EL PASO COUNTY FILE NO. SF2614

CALM BREEZE FILING NO. 1

STREET IMPROVEMENT PLANS

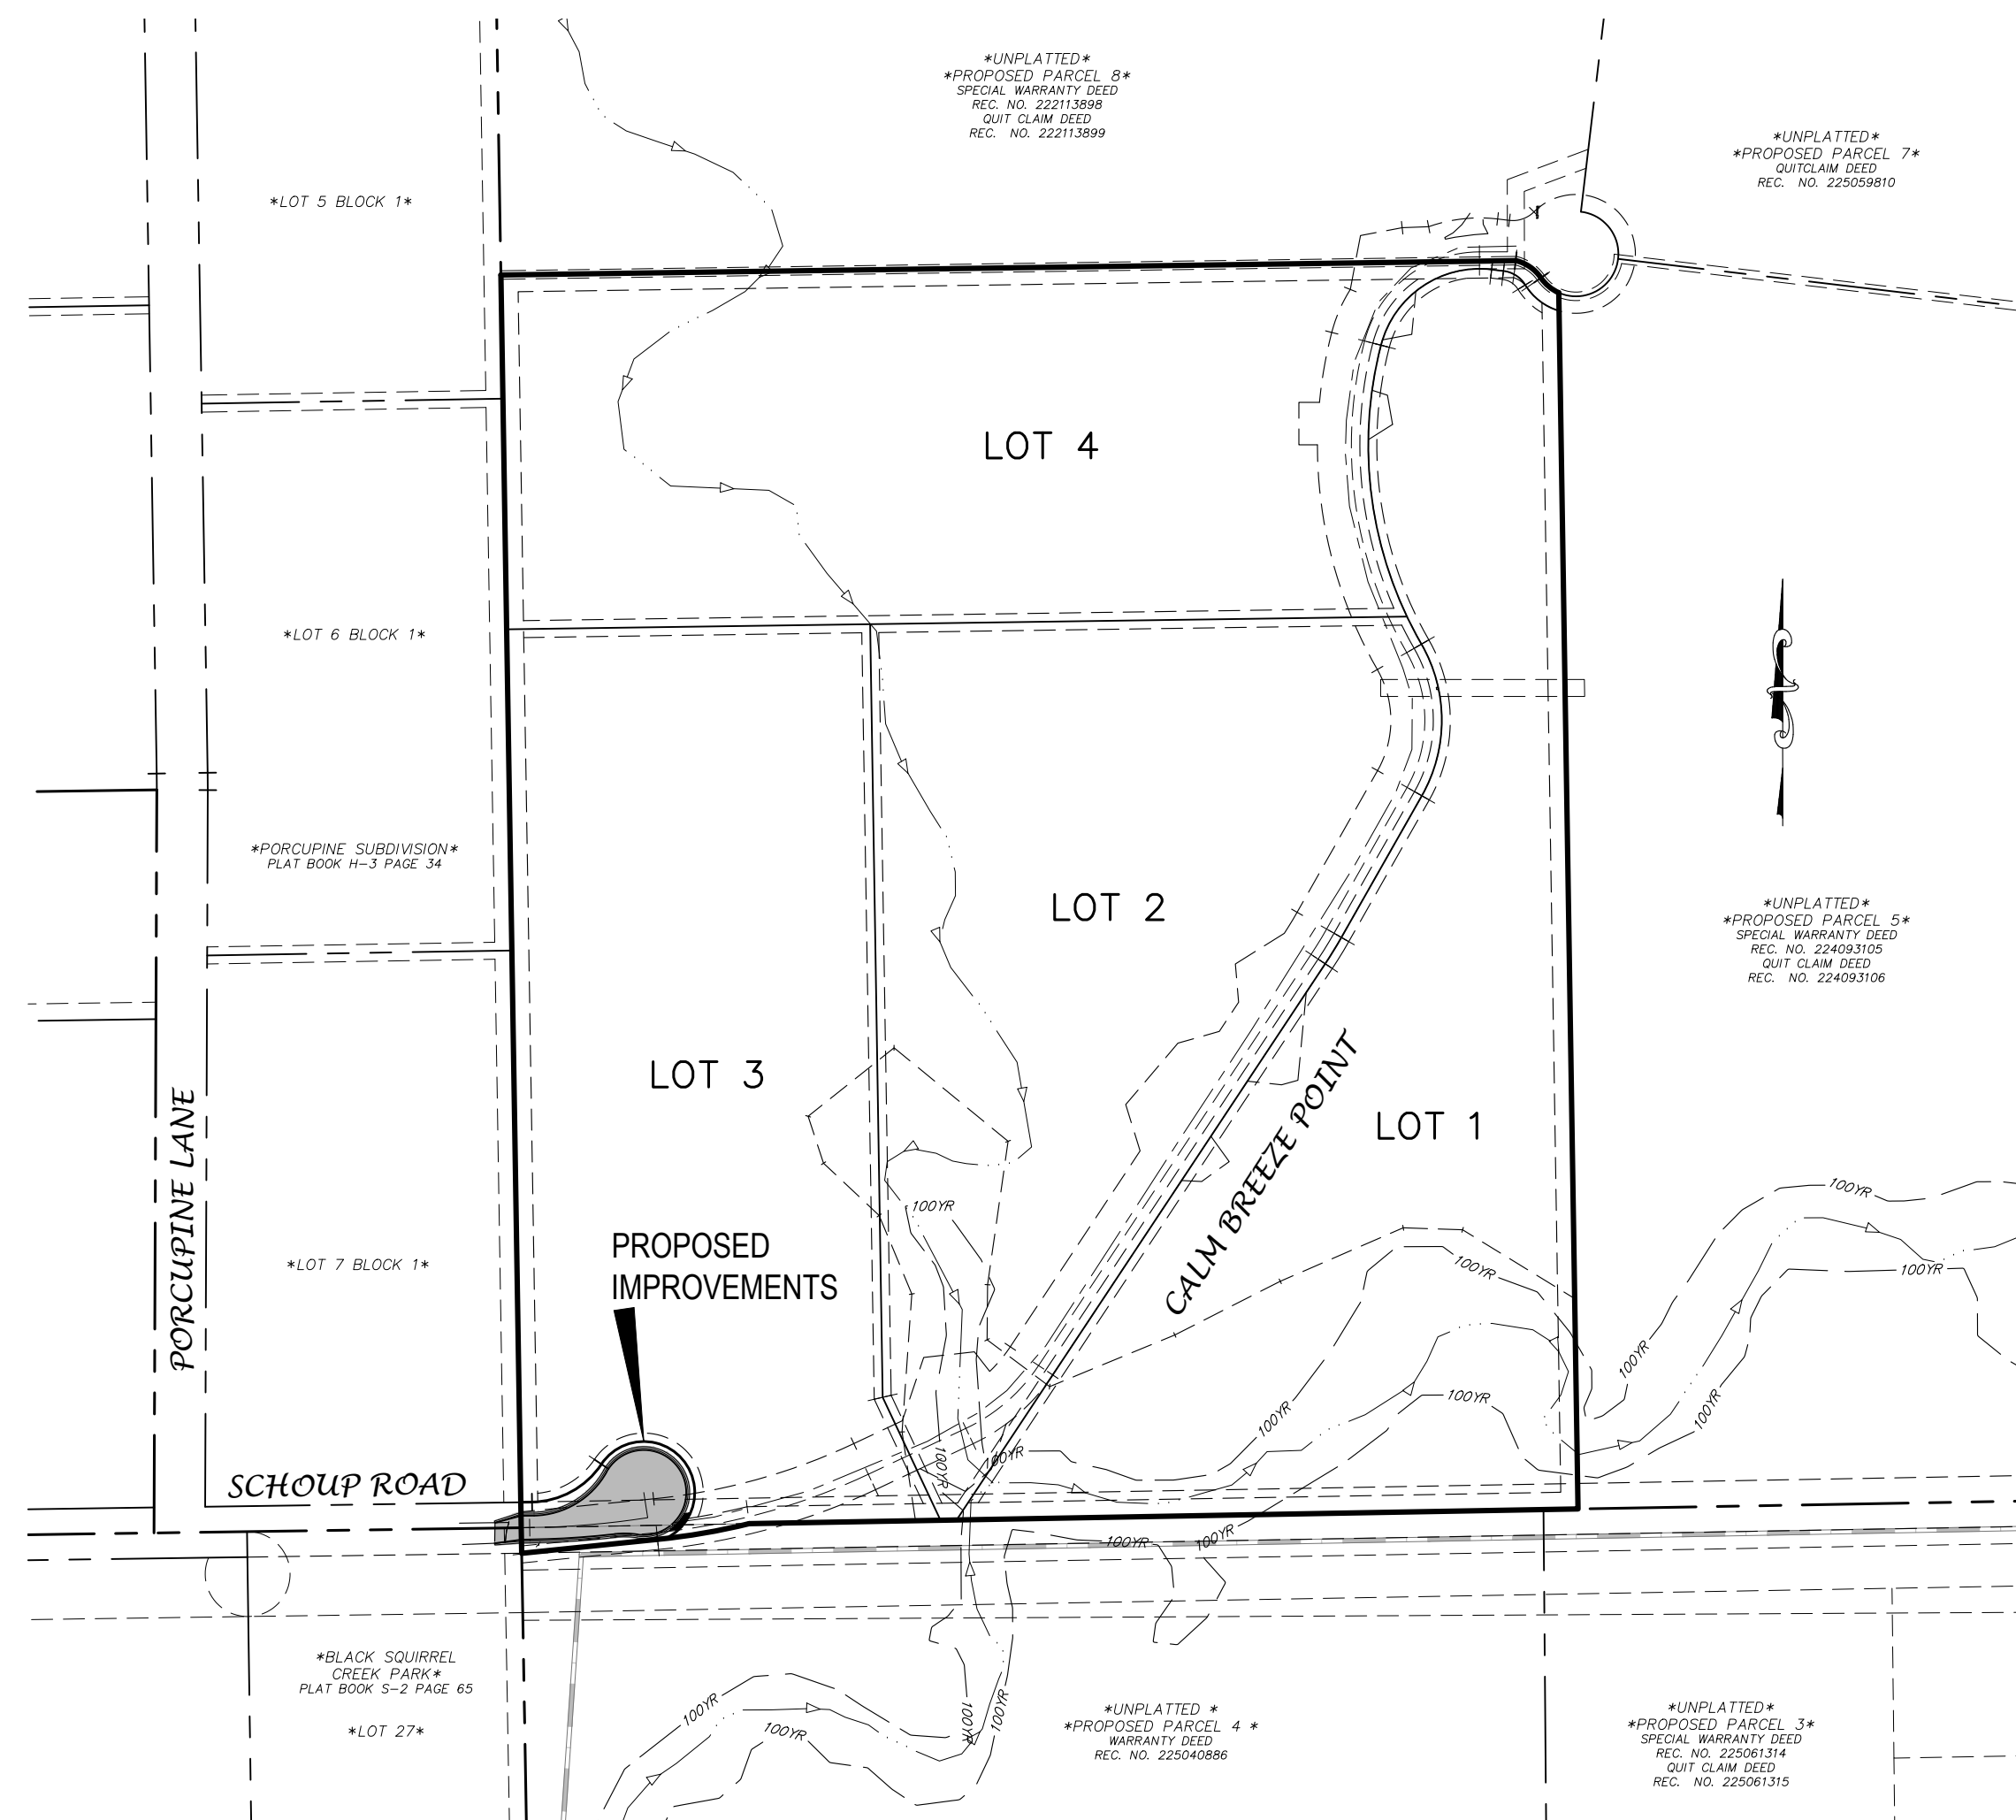
Use the Construction Drawings signature block from the County Engineer page.

Please include 2 owner signature lines

**CALM BREEZE FILING NO. 1**  
**STREET IMPROVEMENT PLANS**  
 PROJECT NO. 08-101  
 DATE: 05/19/2026  
 SCALE: HORIZONTAL: 1"=20' VERTICAL: 1"=2'  
 DESIGNED BY: GW  
 DRAWN BY: EY  
 CHECKED BY: VAS  
 SHEET 3 OF 10  
 S103

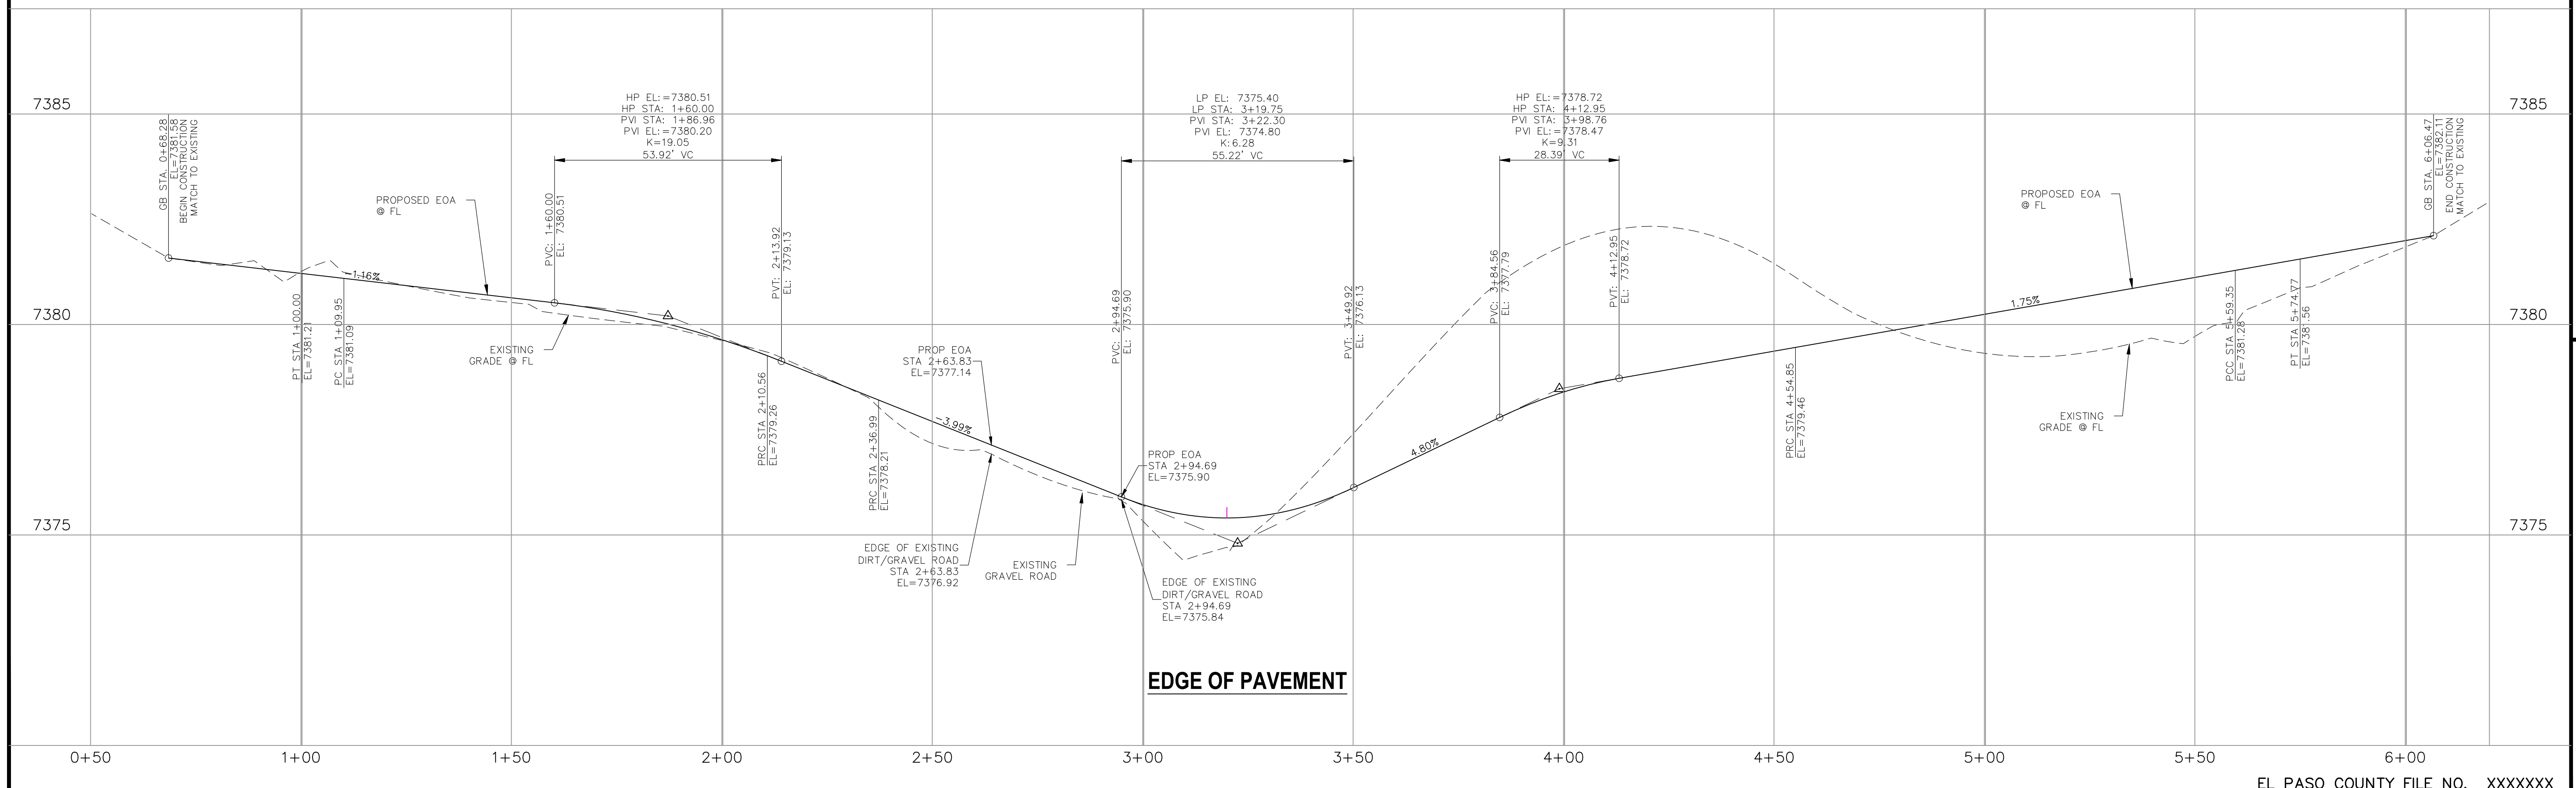
Include roadway structural section detail.

Sign should be relocated outside the clear zone.
